14 September 2021

Your Ref: SSD-15882721

**Comments on Doran Drive Plaza Precinct
LOT 55 in DP 1253217**

HTT12.5 to HTT15 - 250 Turntable Specification

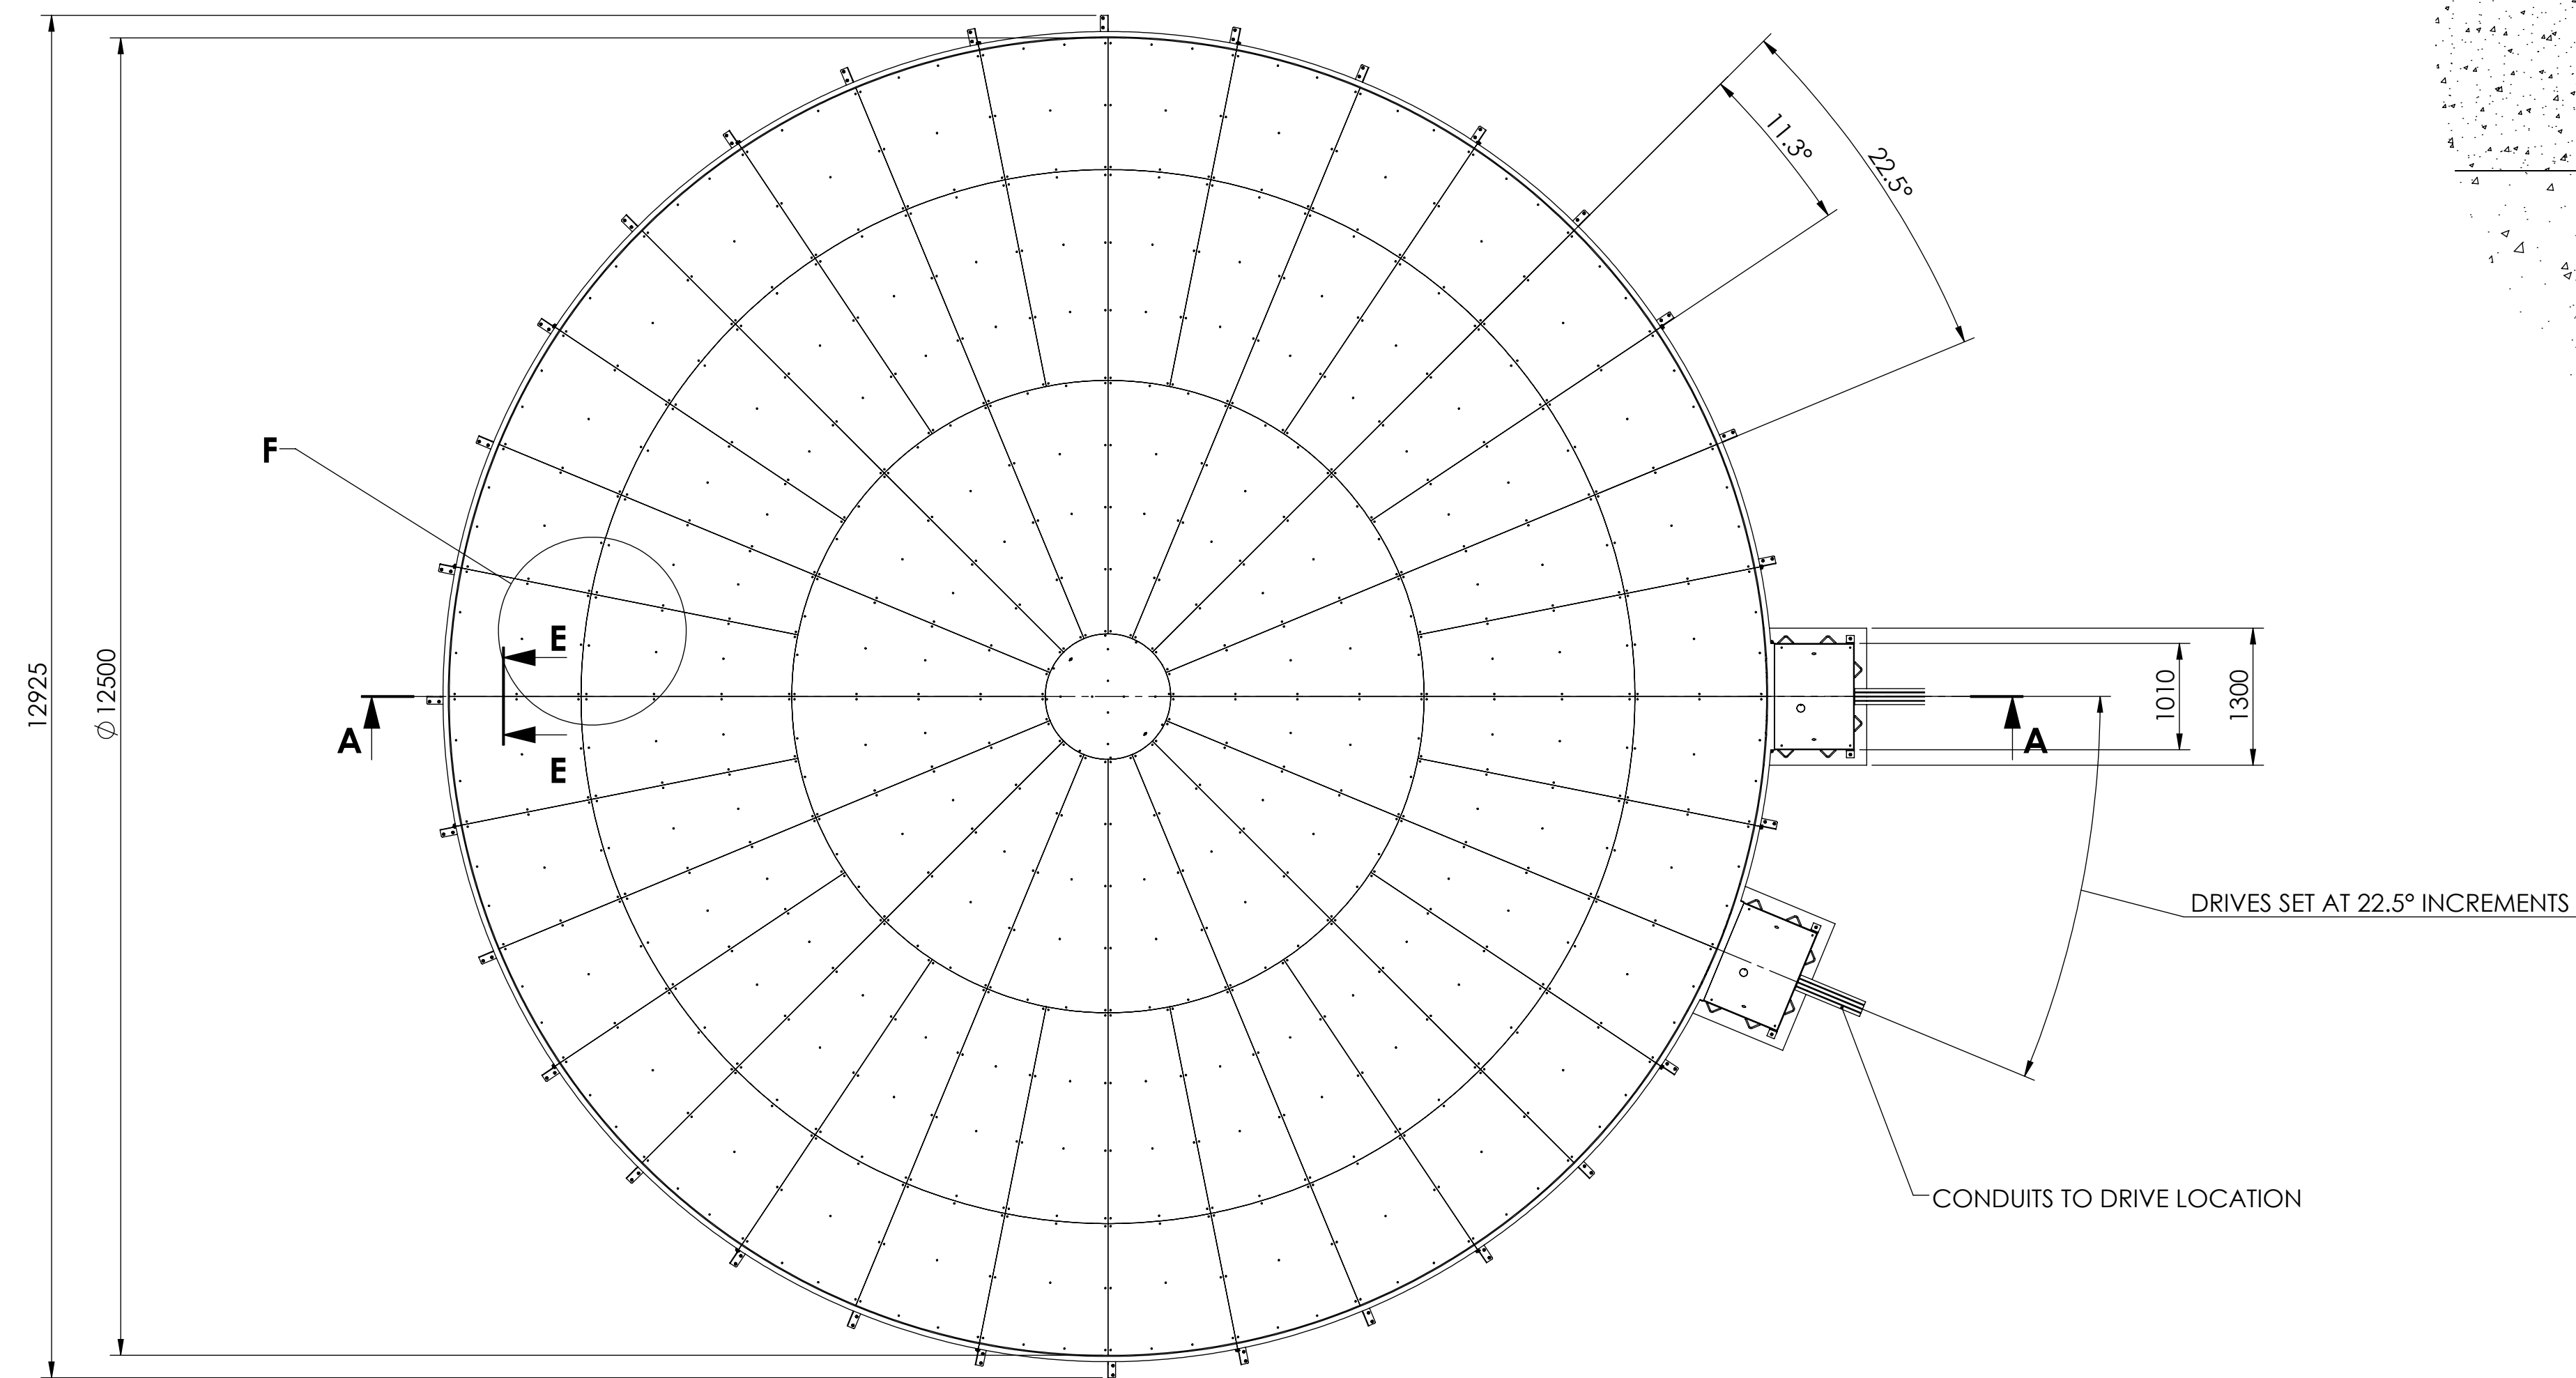
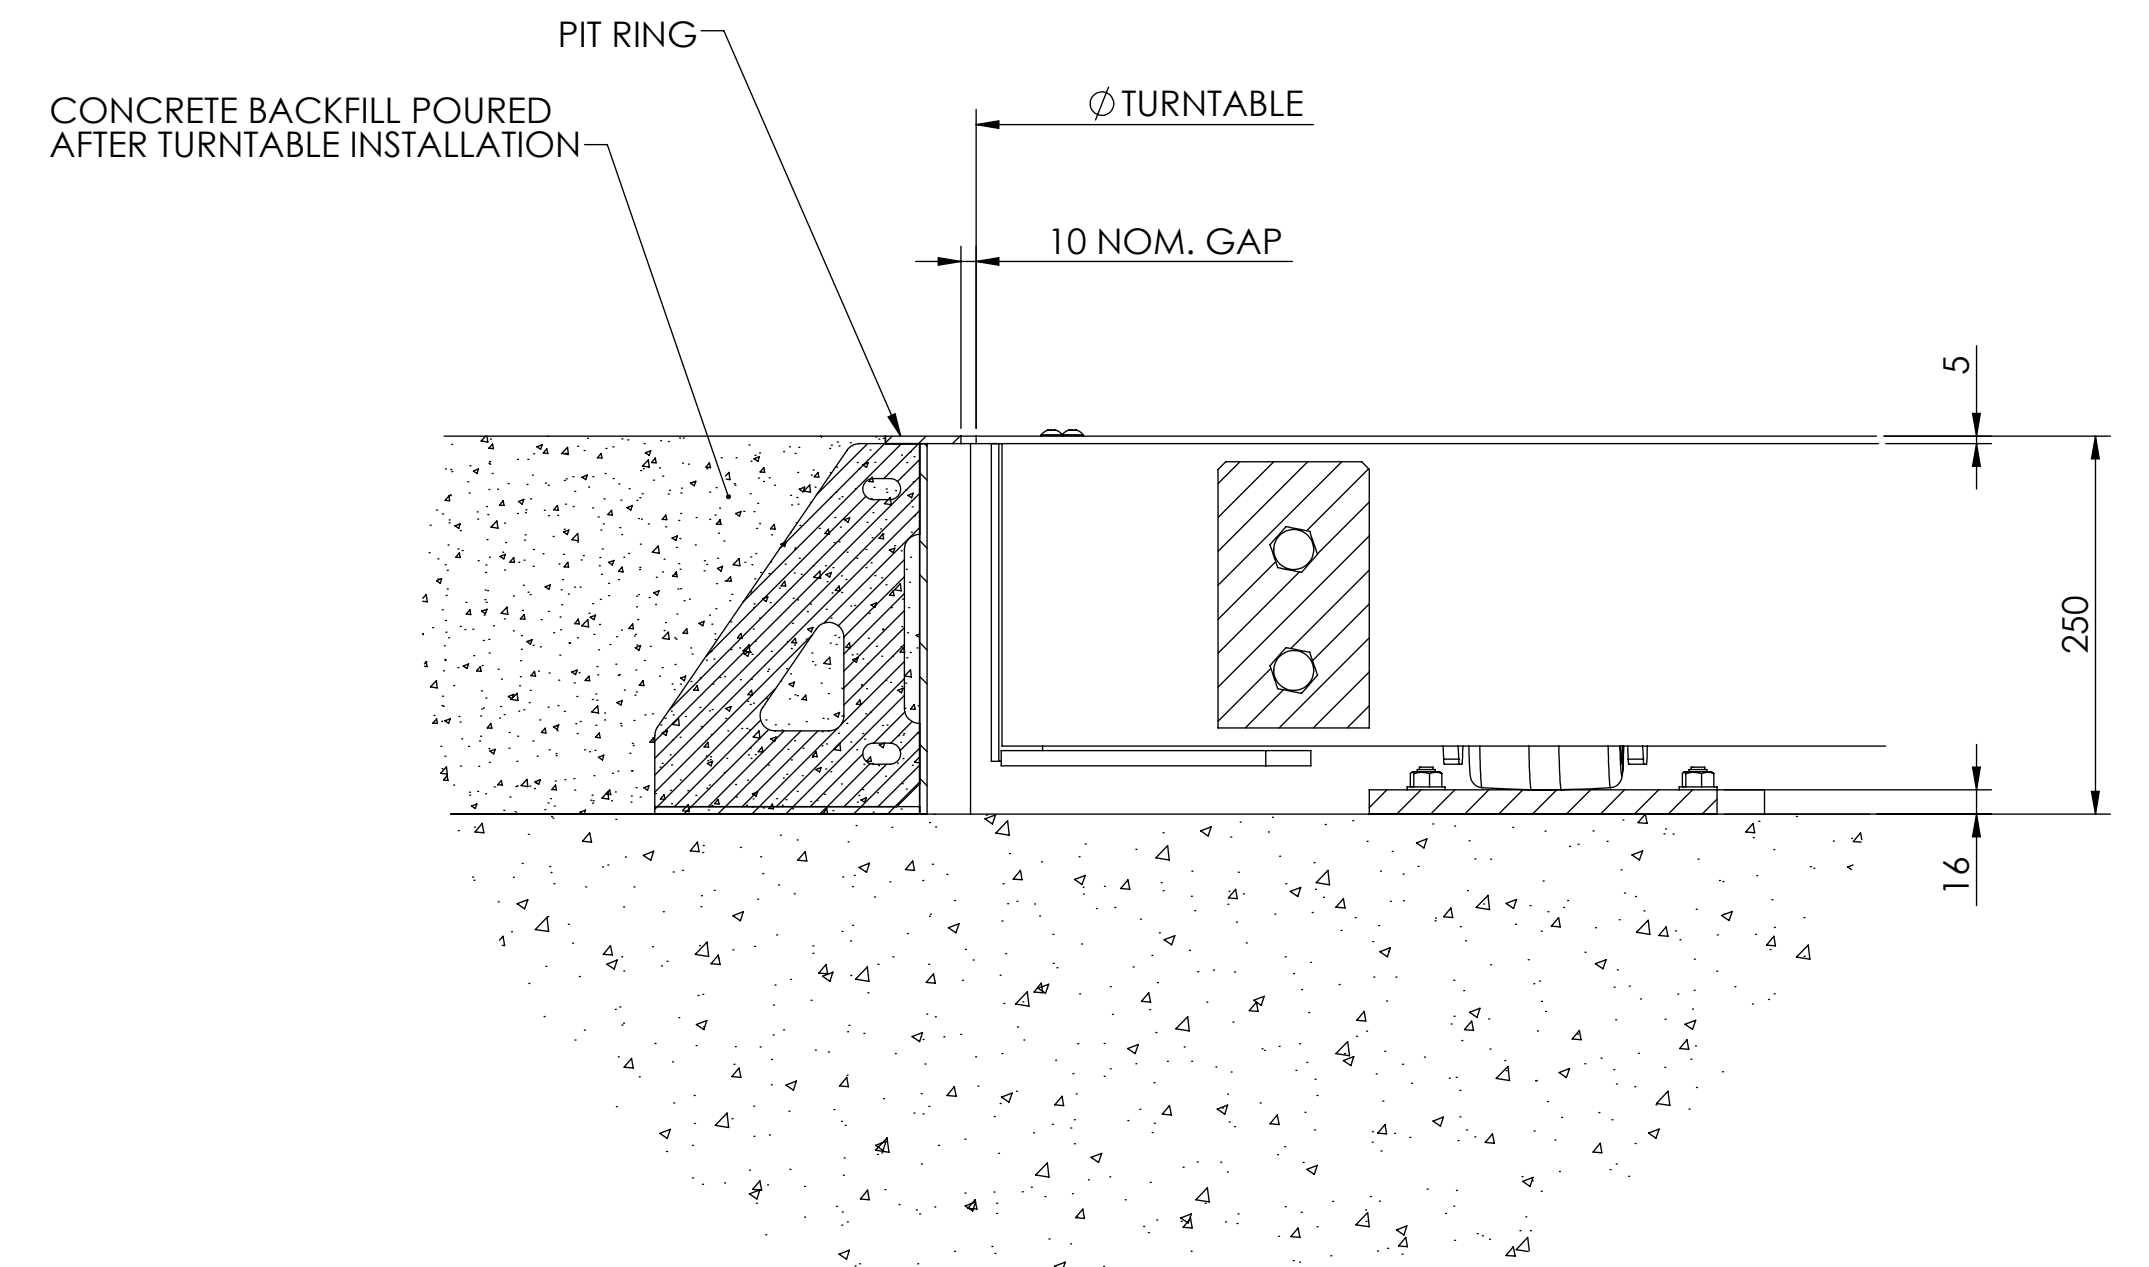
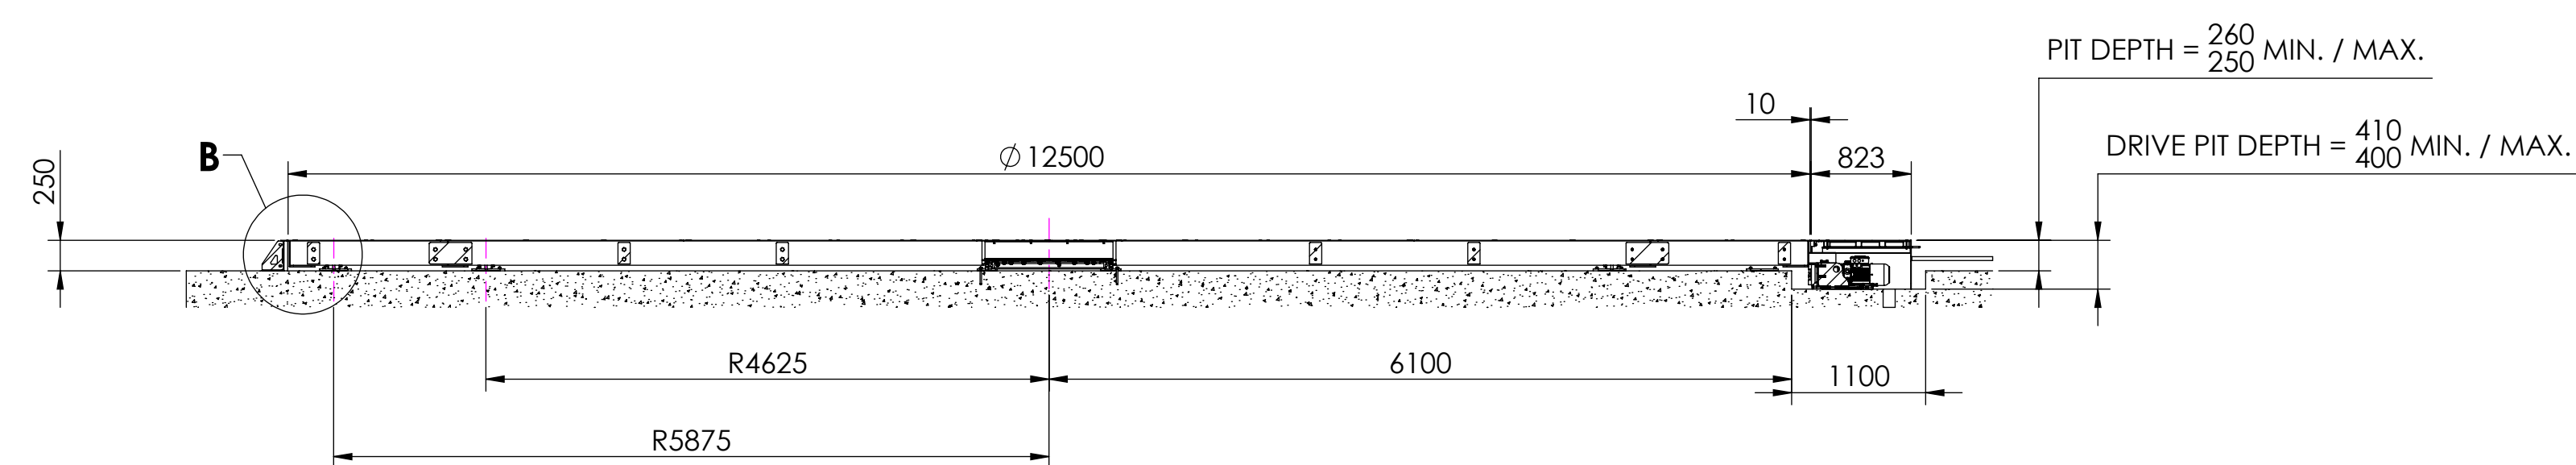
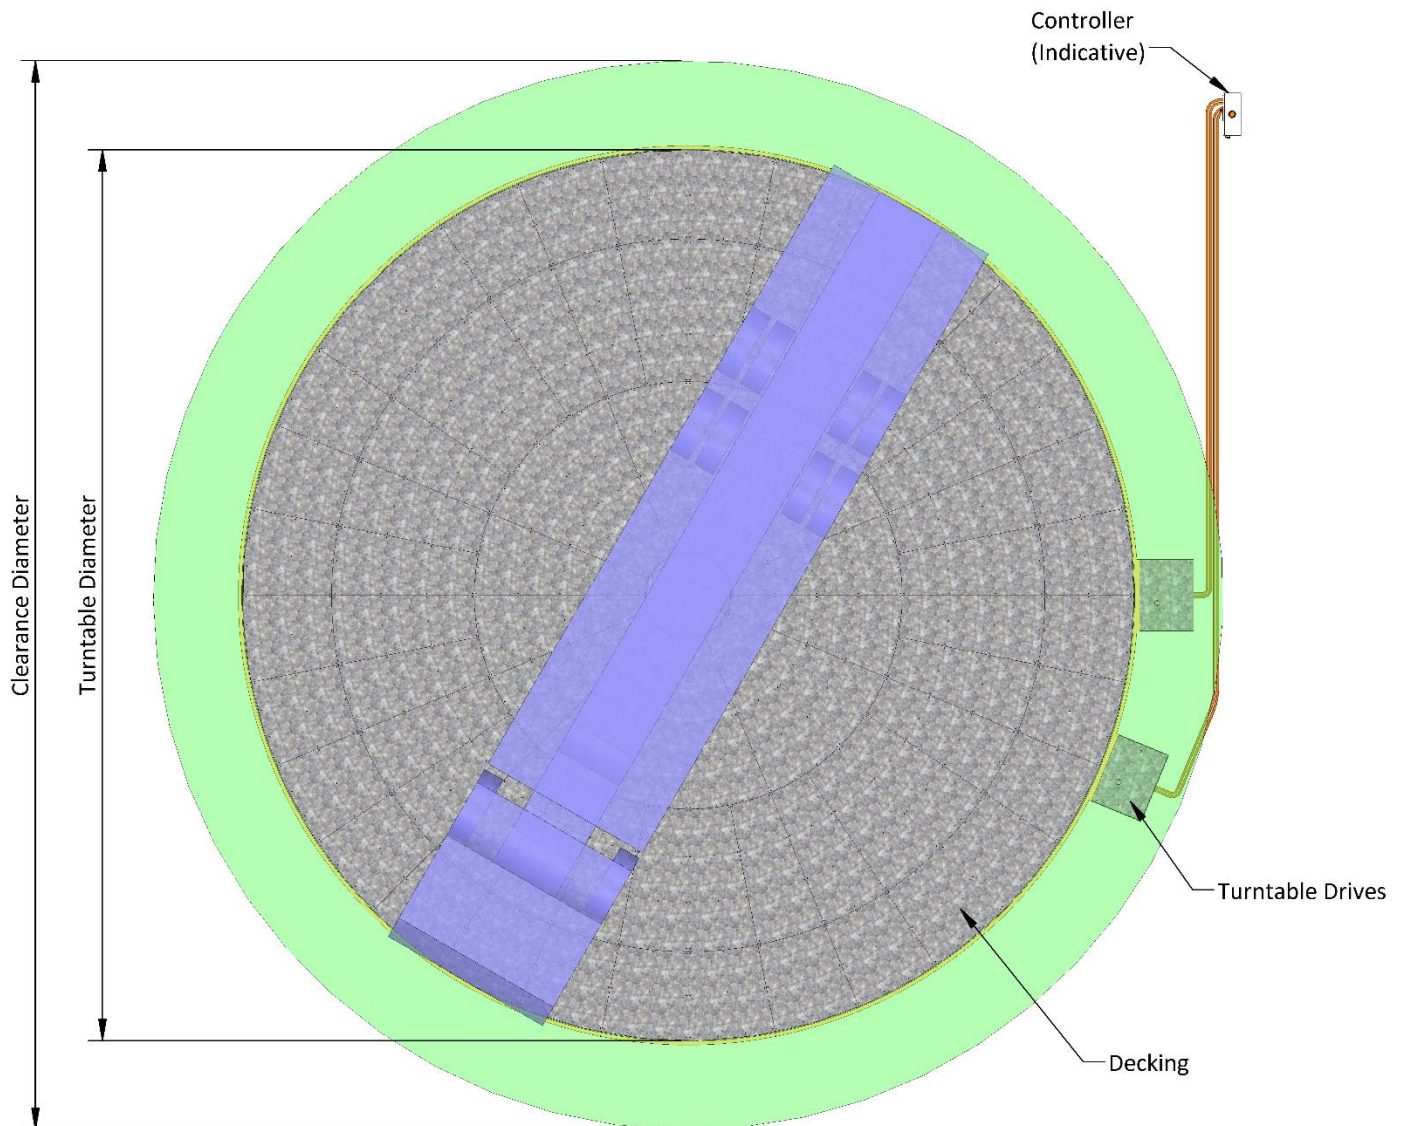
- Turntables are not typically supported within The Hills Shire Council. Council’s standard is for vehicular access and loading designs to rely on a typical three-point turn arrangement to enable waste collection vehicles to enter and leave the site in a forward direction. This arrangement is far more cost effective for all stakeholders and also avoids/reduces ongoing operational risks. Turntables are costly to install and maintain throughout their lifetime. According to WSROC’s Residential Flat Building Waste Collection Infrastructure Fact Sheet turntables may incur \$32,000 to \$101,000 upfront costs with \$1,000 to \$3,000 per annum maintenance costs over an expected lifetime of 10 years. Furthermore, if the turntable malfunctions or does not operated at full capacity there is the potential for a significant impact on waste collections being able to be completed. Additionally, if this occurs at the time when the waste vehicle is positioning itself to enter the loading bays, the waste vehicle will be required to exit reversing out of the site. This potentially could cause significant traffic or safety issues.
